COMMUNITY SERVICES DEPARTMENT

December 9, 2020

Subject: Homestead North at Sterling Ranch Phase I Preliminary Plan and Rezone – Preliminary Comments (SP-20-008, P-20-005)

PRELIMINARY SITE PLAN

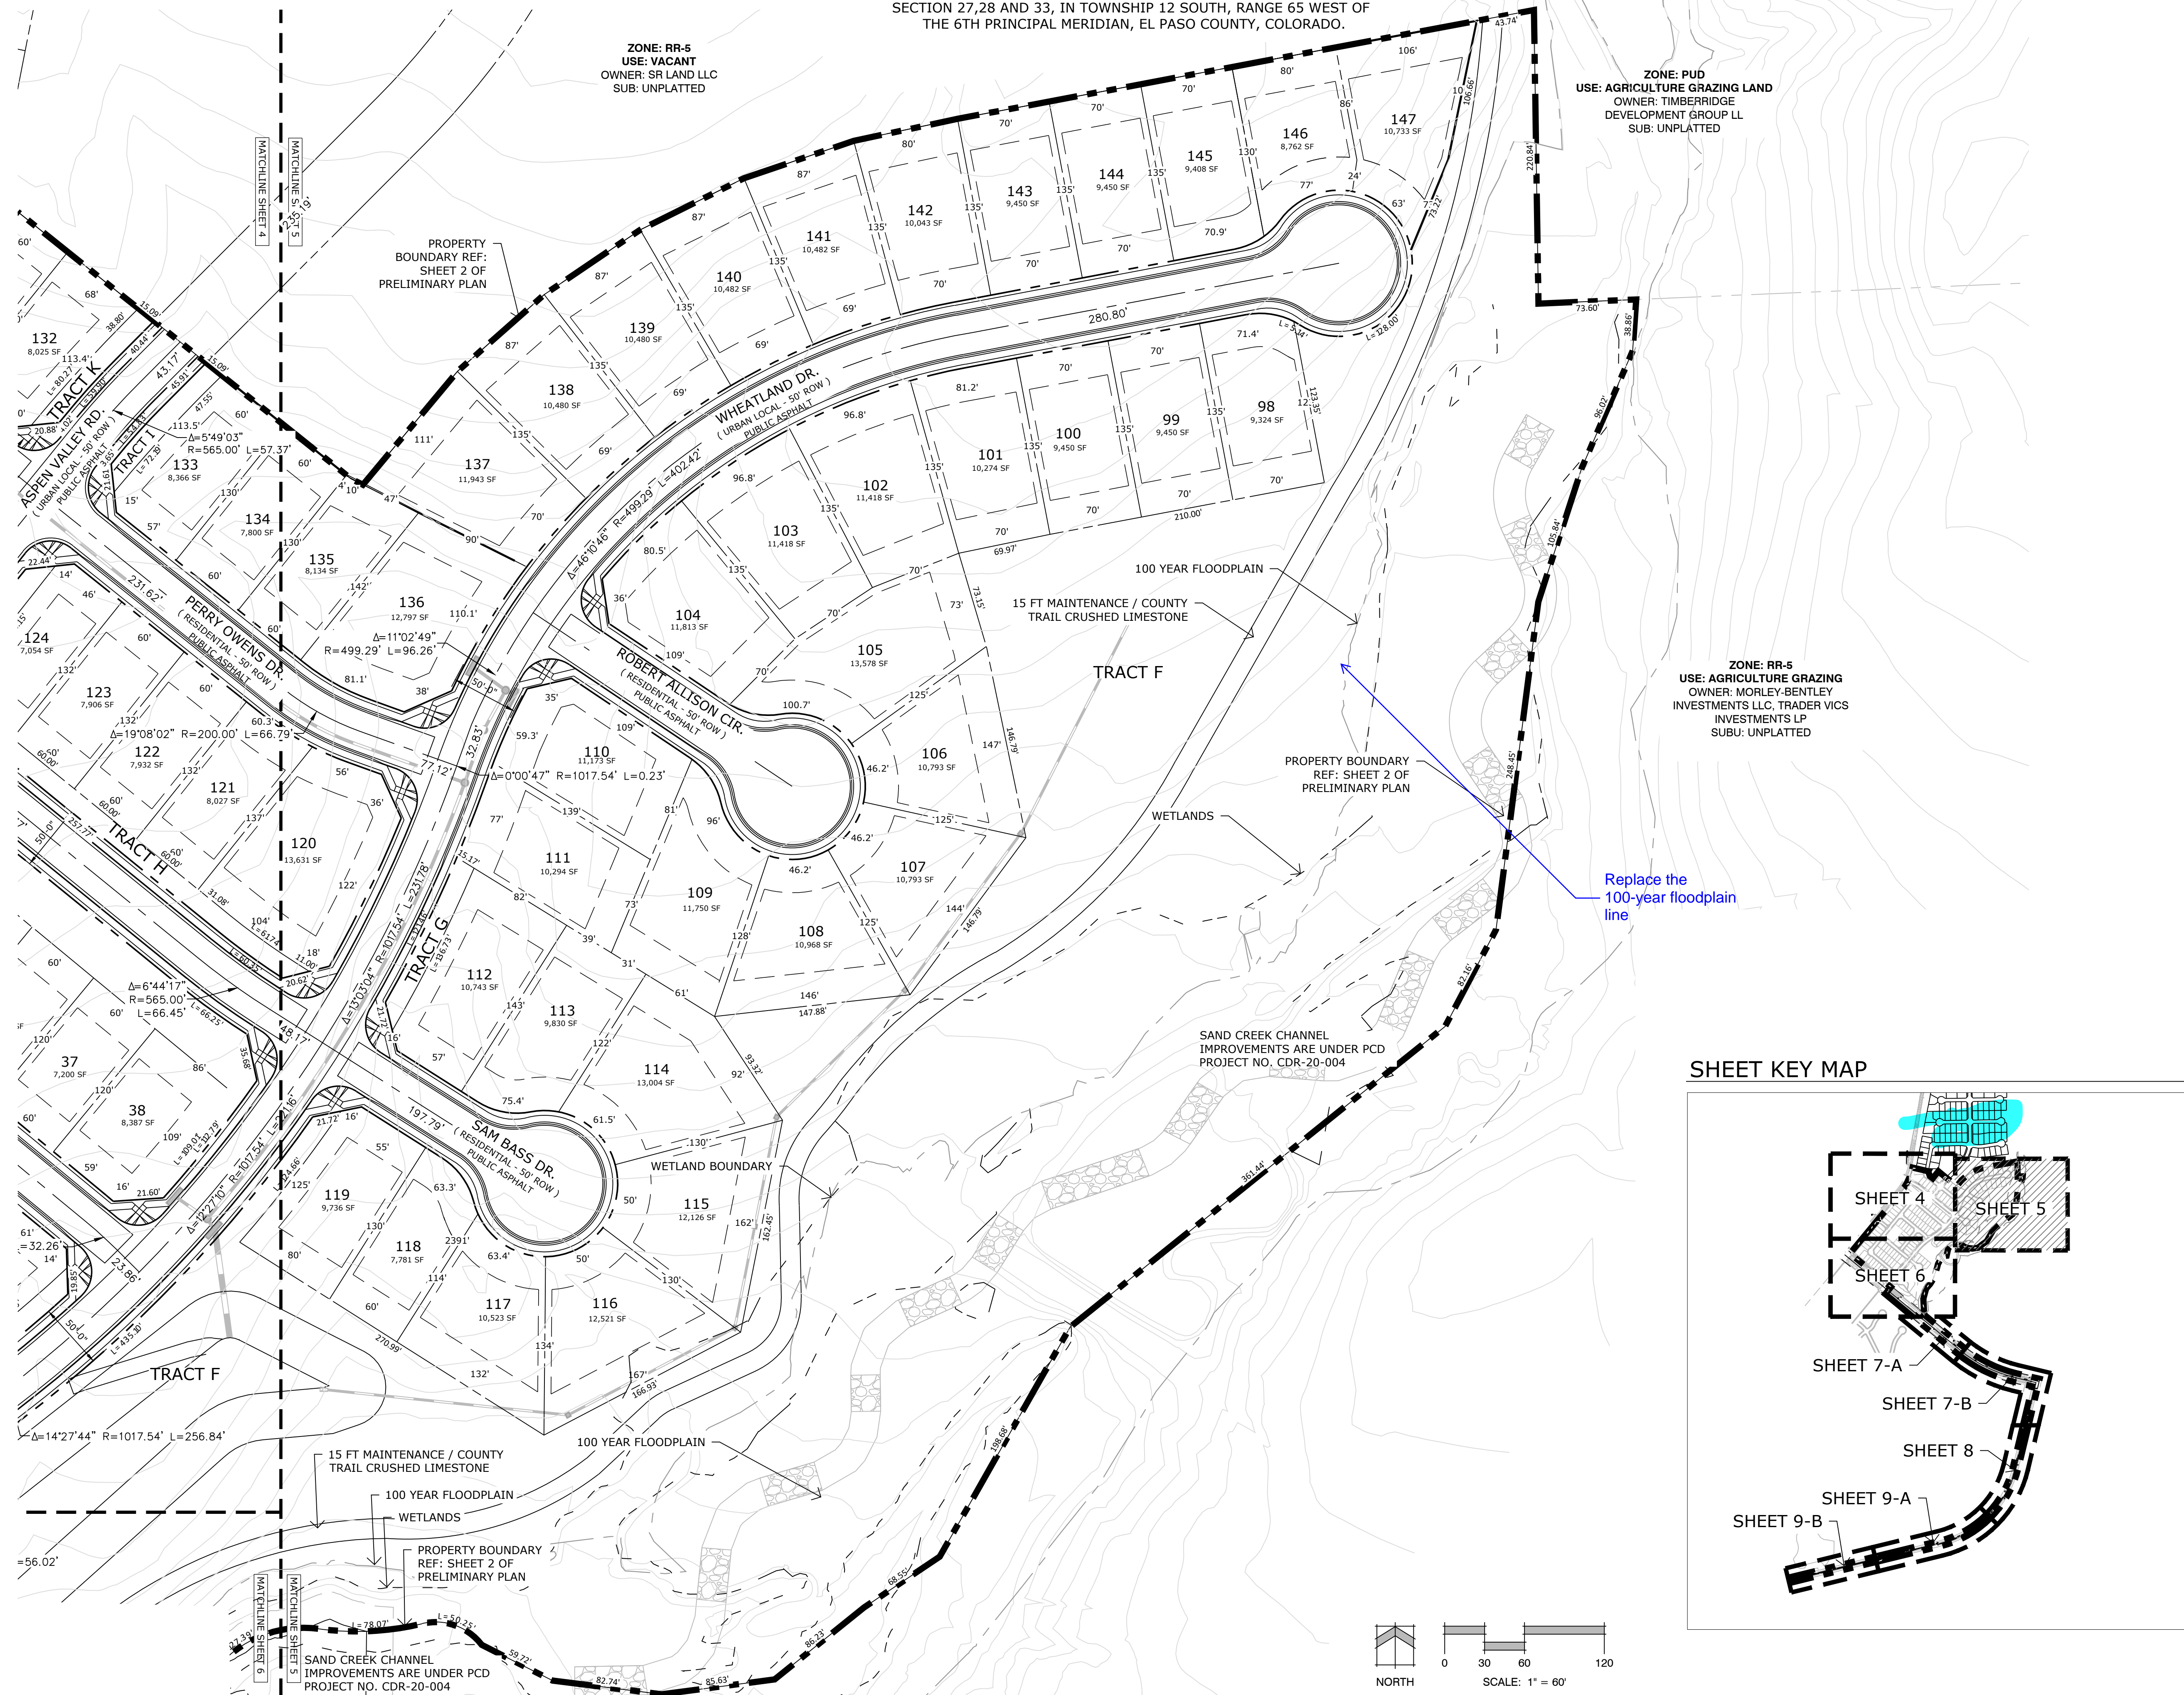
The proposed Sand Creek Regional Trail is depicted in the Preliminary Plan, and labeled as “10’ County Gravel Trail,” although when constructed, the trail will follow EPC Parks Tier I Trail standards with an 8’ wide crusher fine trail surface with 2’ natural shoulders. The Preliminary Plan also shows concrete sidewalks/trails located adjacent Vollmer Road and the future Briargate Parkway extension. These non-County trails will allow for direct off-street connectivity to the Sand Creek Regional Trail for the residents and visitors of Sterling Ranch.

Due to the location of the Sand Creek Primary Regional Trail within the Homestead North at Sterling Ranch Phase I development, El Paso County Parks staff recommends that the applicant designate, provide, and dedicate to El Paso County a 25-foot trail easement that allows for the construction, maintenance, and public access of the regional trail. Furthermore, staff recommends fees in lieu of land dedication for regional and urban park purposes.

The Park Advisory Board recommends that the Planning Commission and the Board of County Commissioners include the following conditions when considering and/or approving the Homestead North at Sterling Ranch Phase I Preliminary Plan: (1) designate and provide to El Paso County a 25-foot trail easement through Homestead North at Sterling Ranch, within Tract F, that allows for construction, maintenance, and public access of the Sand Creek Primary Regional Trail, and dedicate the easement to El Paso County prior to the recording of the forthcoming final plat(s); 2) include descriptions, drawings, and locations of the two neighborhood parks in the Letter of Intent and Preliminary Plans, respectively; 3) fees in lieu of land dedication for regional park purposes in the amount of \$68,649 and urban park fees in the amount of \$43,365 will be required upon recording of the forthcoming final plat(s). A Park Lands Agreement may be an acceptable alternative to urban park fees, provided the agreement is approved by the County and executed prior to recording the forthcoming final plat(s).
